Walmart / Rio Bravo

REPLACEMENT CULVERTS

**ARENAL MAIN CANAL/RIO BRAVO BOULEVARD
CROSSING AT ISLETA DRAIN**

Subject: Wal-Mart @ Rio Bravo/Coors**COMMENTS:**

**ISLETA DRAIN
12' x 6' CBC DETAIL**

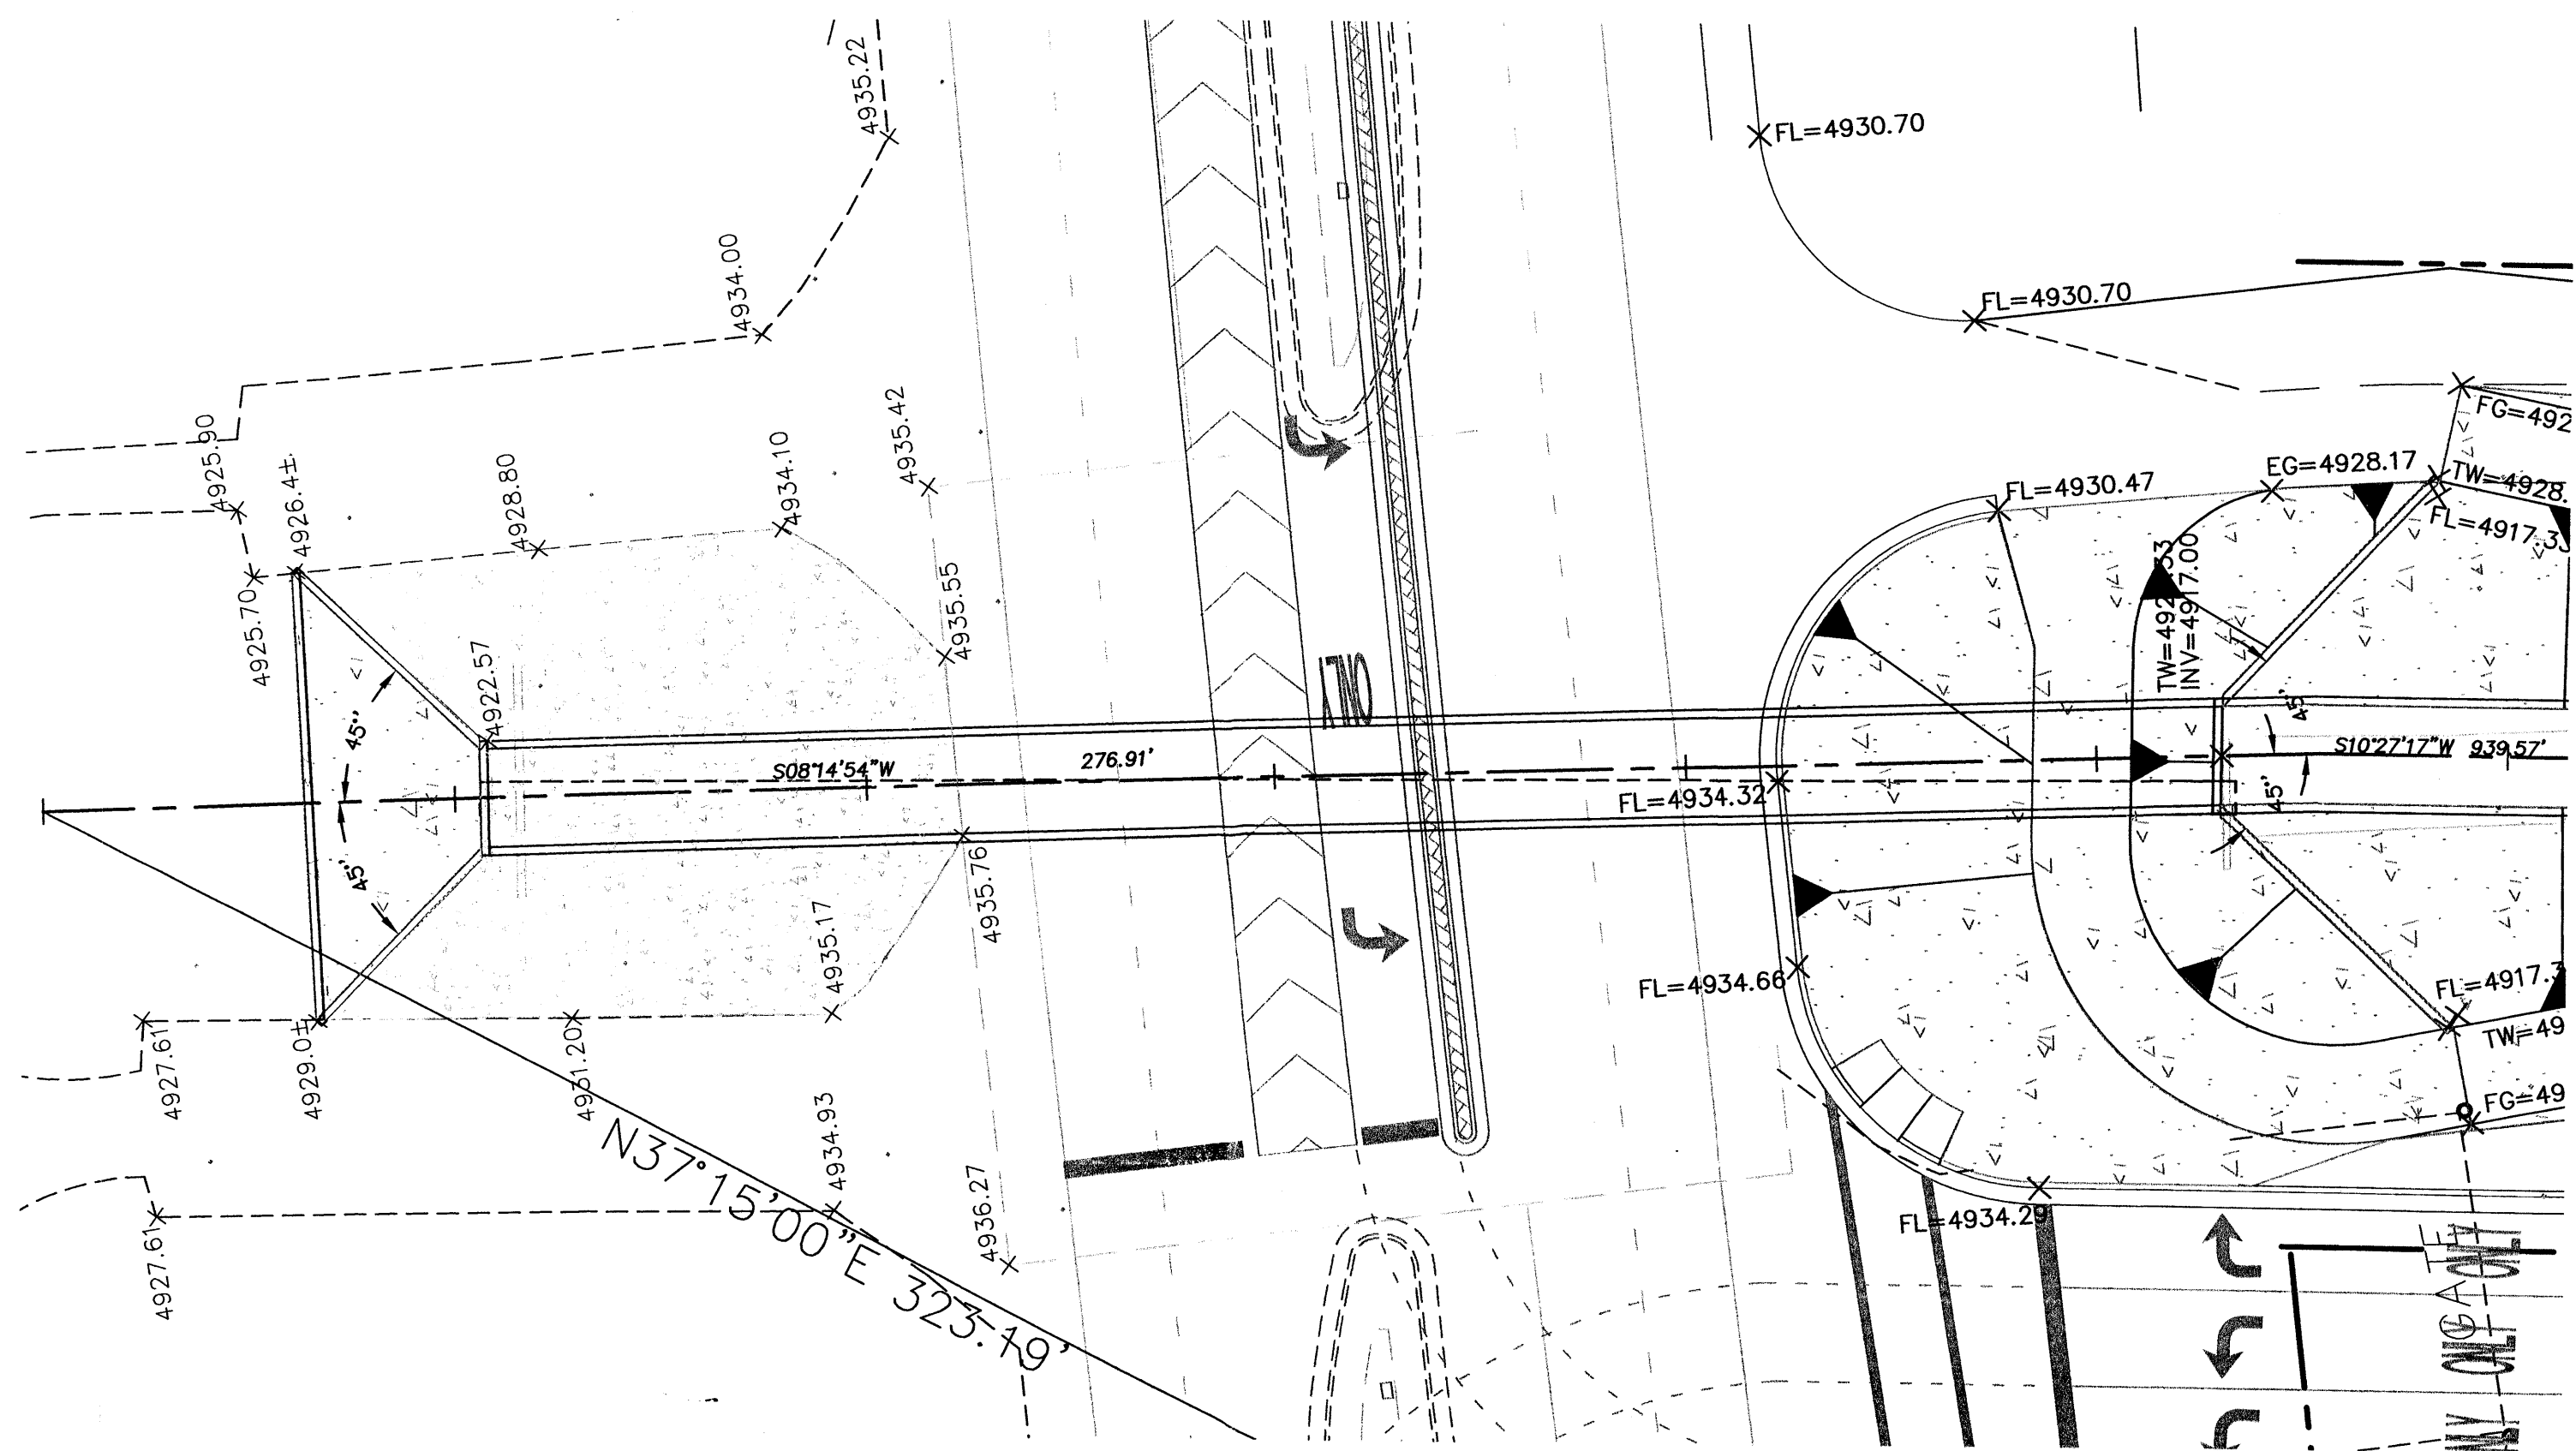
Here is the report we had RTI prepare for the Rio Bravo crossing of Isleta Drain. You were copied on a letter from MRGCD that stated that they will not approve a double box culvert. Therefore, you need to put a single 12' x 6' CBC on the Infrastructure List. You may come up with an alternate design for final, but we will need to meet with MRGCD to coordinate.

The District has reviewed your feasibility design for the above referenced. The District recommends the existing road culvert pipe be replaced with a single barrel concrete box culvert or a trapezoidal concrete box culvert.

*Drain needs to be dredged 2' to Lakeview.
1-12' x 6' C.B.C. - or - equivalent*
